**Cover Letter to Submission - State Significant Development
(SSD-80432461) – Infill Affordable Housing at 2-6 Pilgrim Avenue and 11-13 Albert
Road, Strathfield**

Strathfield Council Submission to State Significant Development (SSD-80432461) – Infill Affordable Housing Development – August 2025

Figure 16 Basement Section Plan (North-South)

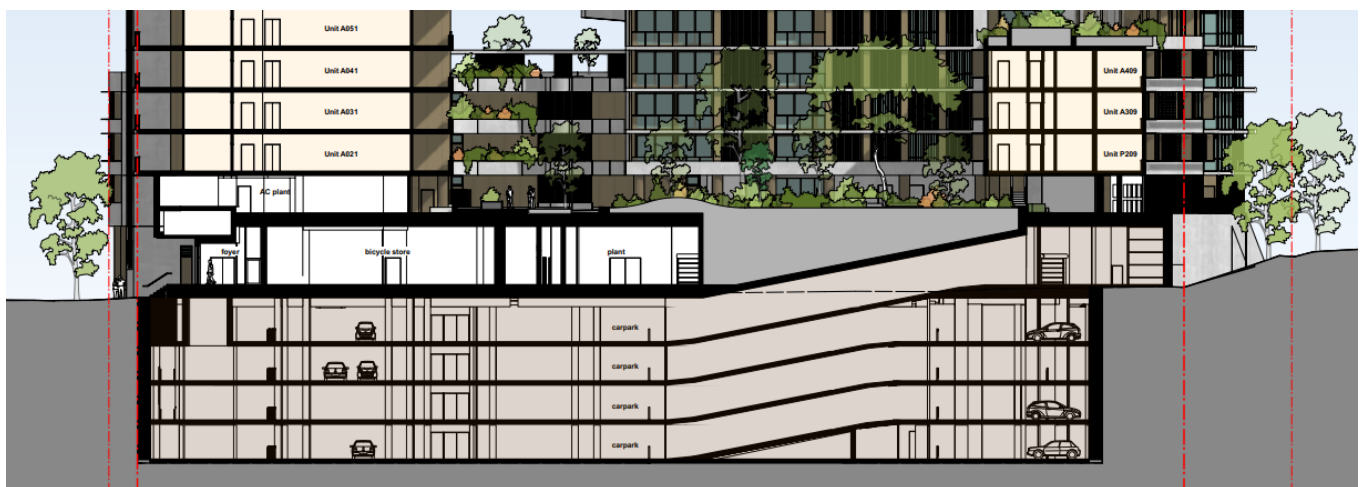
The proposal should follow a similar setback to that approved under the previous application on the site (DA2020/256). This would enable improved separation from the row of neighbouring trees to 9 Albert Road and will be less likely to adversely impact the root systems along with providing more deep soil zone for the site.

Figure 21 Wintergardens Plan

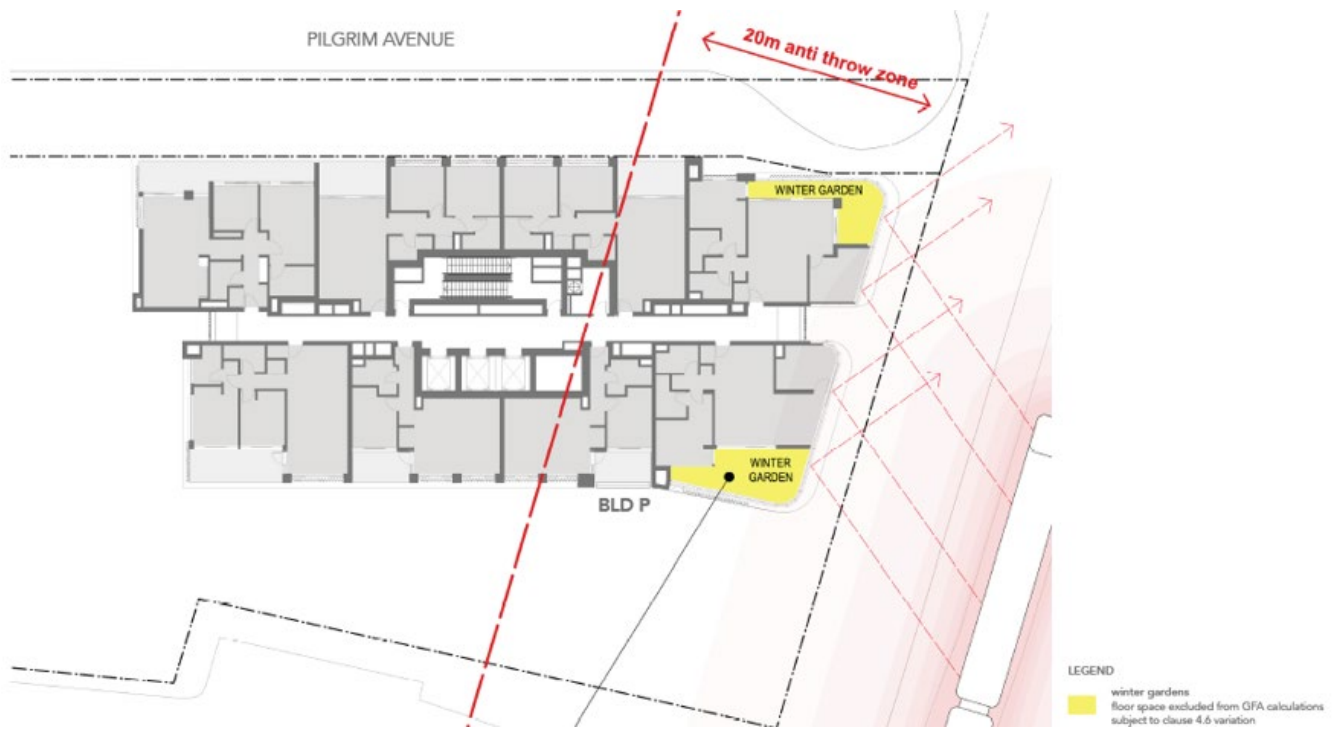
- Winter garden design should be more carefully considered with specific regards to maintaining cross ventilation whilst addressing anti-throw requirements for the adjoining railway line.
- Council does not support cross-ventilation via plenums. It is strongly recommended that apartments are converted (where possible) into 2-storey 3+ bedroom units in order to achieve the following:

Figure 23 Ground Floor Landscape Plan

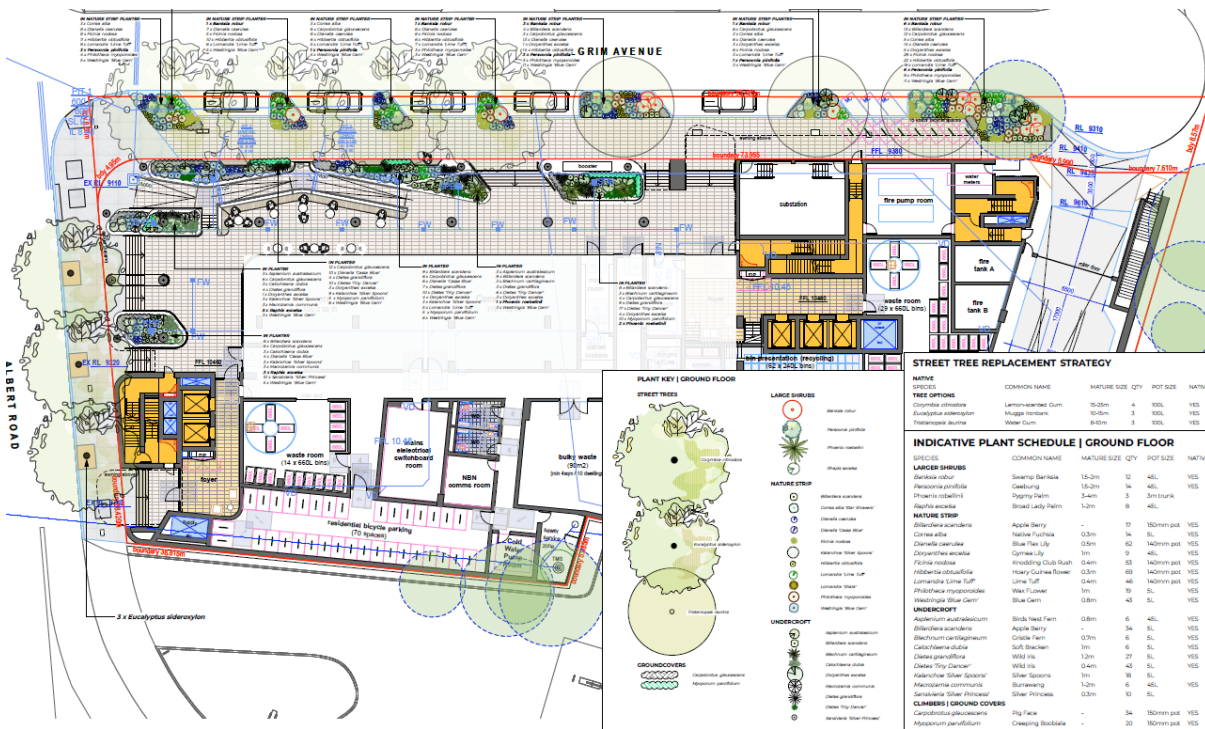
The increase in street trees along Albert Rod and Pilgrim Avenue is generally supported. Tree 2 *Tristaniopsis laurina* (SRZ 2.76m TPZ 6.4m) located on Pilgrim Avenue is to be retained and protected as it appears to be in good health and condition. The tree provides a remarkable canopy for its species, contributing to the urban canopy coverage of Strathfield. Note from onsite inspection canopy does not overhang development boundary.

The architecture/landscape drawings propose removal of Tree 2 to incorporate on street parking. Council would like to see the integration of street parking that retains the tree. Please refer to example below of Watsons Street, Neutral Bay where raised permeable pavement parking spaces have been integrated with retention of the existing Brush box street trees.

Figure 34 Typical Level 6-19 Floor Plan

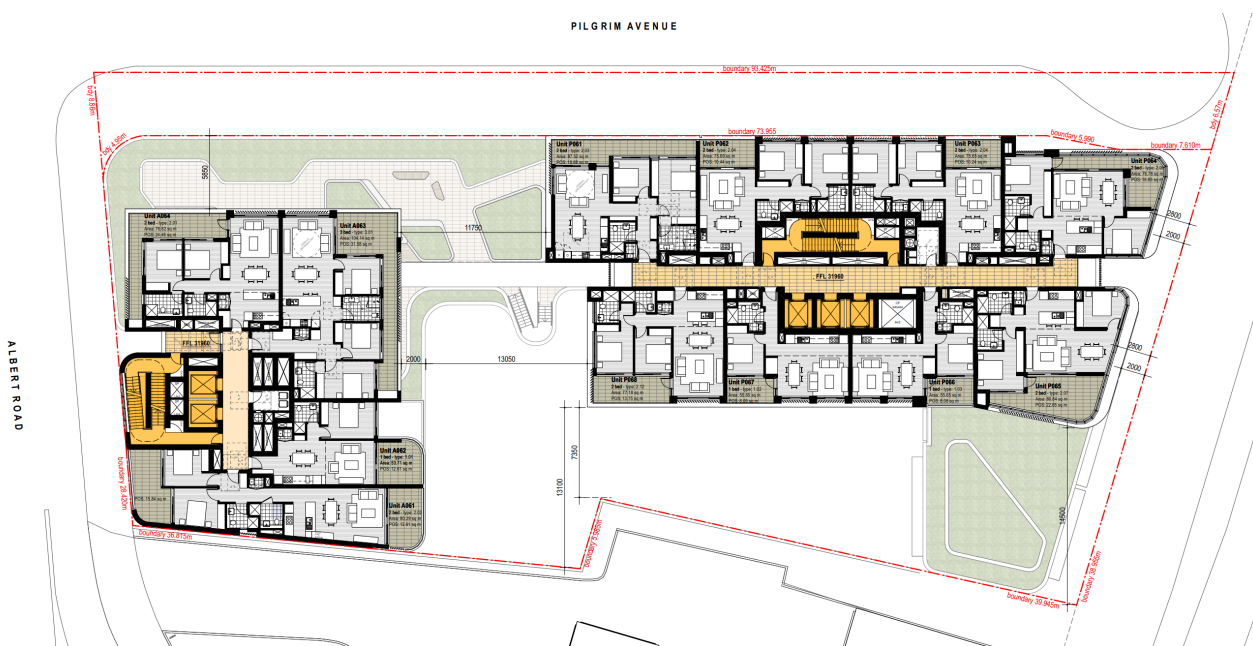
- a. Cross-ventilation (single aspect 2-storey is considered cross-ventilated in the ADG
- b. Increase the % of 3-bedders. 7% is not close enough to a minimum 10% in the ADG, Homebush TOD's 20% mandate and Strathfield councils own strategic plan.

Figure 46 Borehole Locations

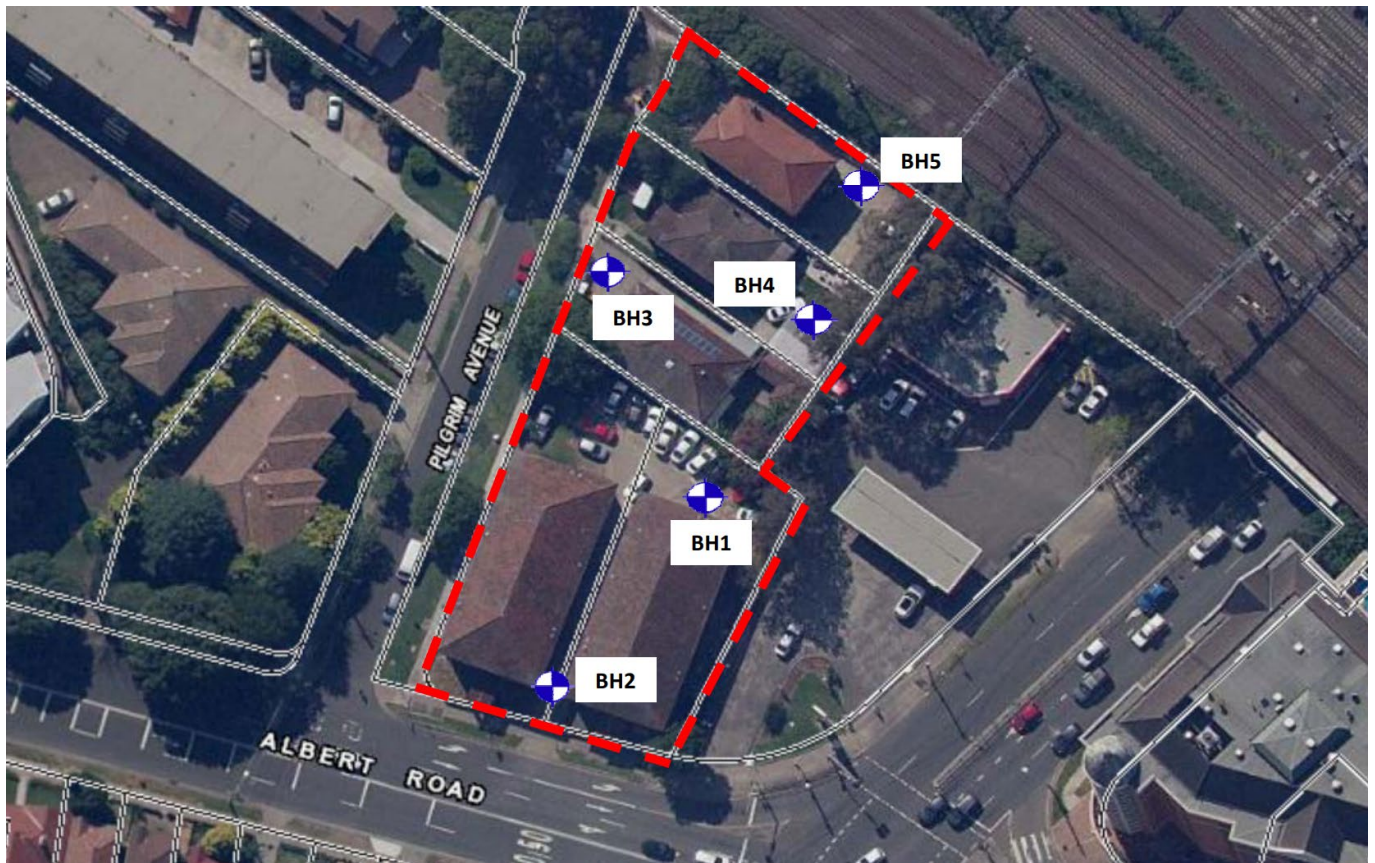
The Geotechnical Investigation report stated that the basement level is about 13.5m below ground level. However, Borehole depths stopped at 11-11.5m below ground level. There was no indication of action to be taken to assess the last 2 m.

Figure 52 1% AEP Peak Flood Depth & Elevation – Post-Development Scenario

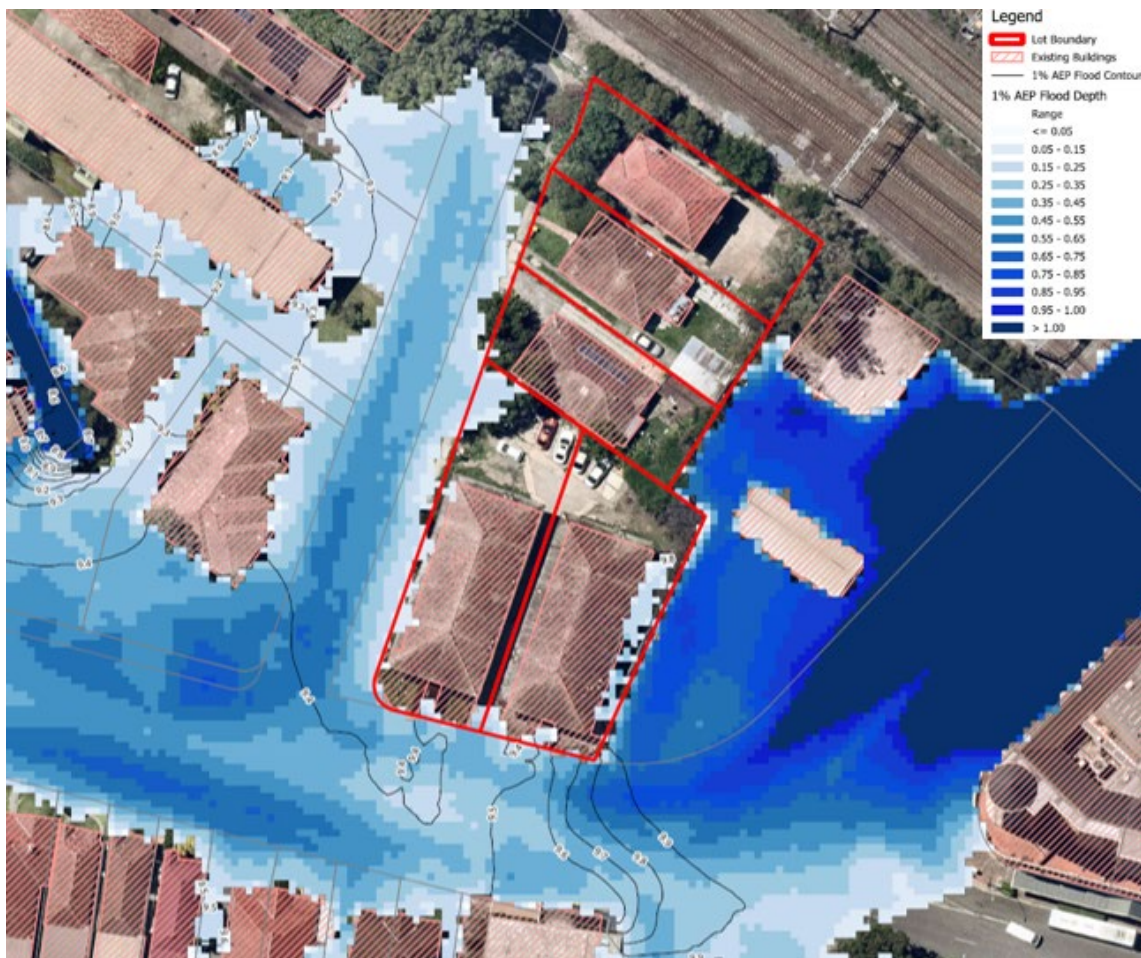
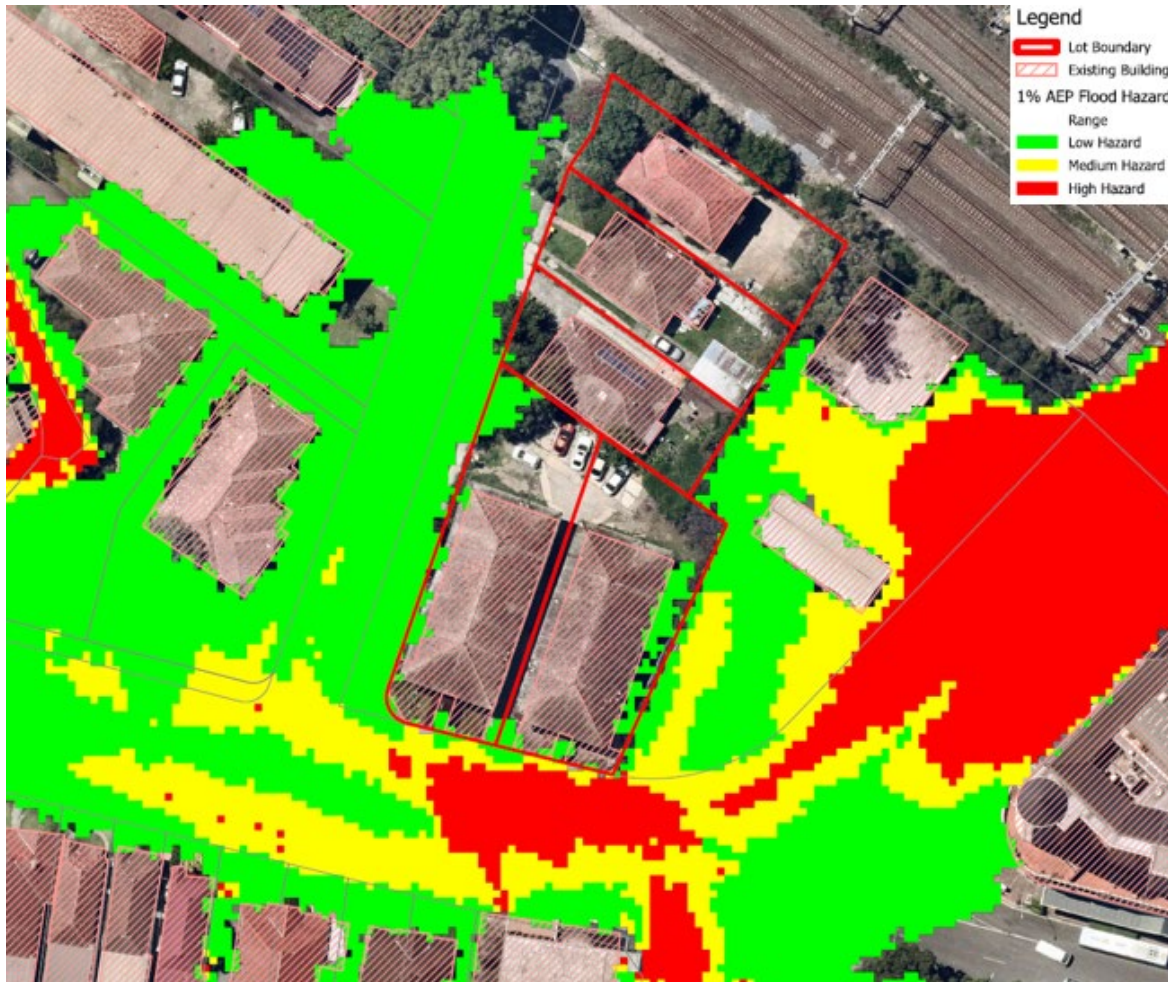
It concluded that there was a decrease of up to 47mm at Albert St, and in the same conclusion an increase of up to 300mm at the southeastern and southwestern corners (basically Albert St frontage).

The overland flood levels range between RL 19.4m AHD and RL 19.9m AHD. While the proposed ground floor levels appear to be above the flood levels, the study stated there was no need to set a minimum crest level in the driveway leading to the 4-level basement. Architectural plans show the driveway level below the flood level.

The driveway should have a crest level of a minimum RL 9.9m AHD located at least 2m inside the boundary line.

- Clarification as to whether the flood levels increasing or decreasing at Albert Road frontage.
- Provision of crest in the driveway at a minimum RL 9.9m AHD, to be located inside the property.
- Statement regarding the assessment of the last 2m of excavation depth.
